From: Tilly Whishaw [REDACTED]
Sent: 28 October 2021 11:33
To: Tim Townsend [REDACTED]
Subject: RE: BN/119/21 - Angels Nursery, Yapton Road, Barnham

From: Tim Townsend [REDACTED]
Sent: 26 October 2021 10:34
To: Tilly Whishaw [REDACTED]
Cc: Chris Pratt [REDACTED]
Subject: BN/119/21 - Angels Nursery, Yapton Road, Barnham

Michael at Arun has consulted me for comments in response to the above planning application – in particular, parts of the internal layout, S278 works, Travel Plan etc. He has sent me replies to my first response to the application and I have been looking at those.

19812-GS-Z1-XX-DR-C-2081

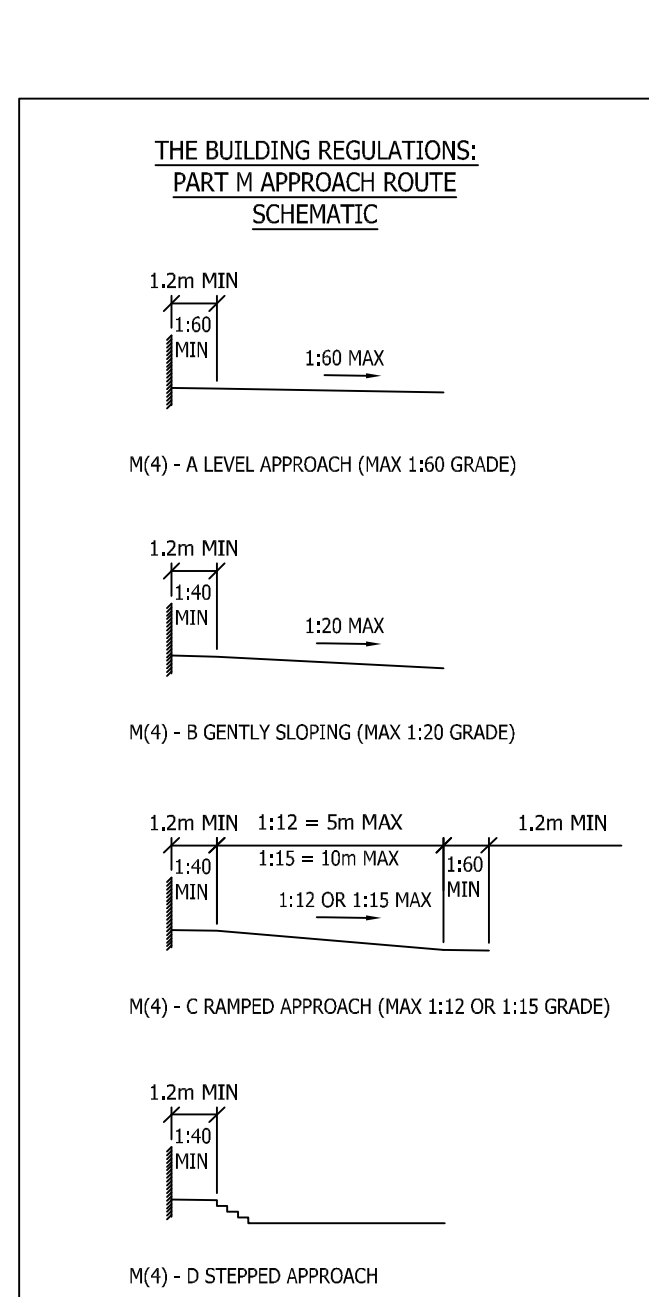
The only apparent outstanding point seems to be with the tie-in point of the cycle/footway as shown below (extract from plan showing how you currently propose things) and as such, I thought it maybe more expedient to approach you directly to try to resolve things:

As shown, it will be particularly difficult for a cyclist to enter or leave the road without overriding the corduroy paving, the tactile paving and part of the ramp. To rectify this would require the corduroy and tactiles being moved southwards and markings provided on the path and – if possible and agreeable with our S38 engineer - on the road away from the ramp. On earlier versions of the internal layout the entry and exit point for the path was further west around the corner and away from conflict points so this might be another option for you/your engineers to consider.

I'd be grateful if you would look into this and provide me with an amended arrangement as soon as possible, please.

Thanks for your email on this. I believe that Chris also discussed this directly with Stephen at Gyoury Self who has sent through the attached updated drawing. Could you confirm that this is now acceptable?
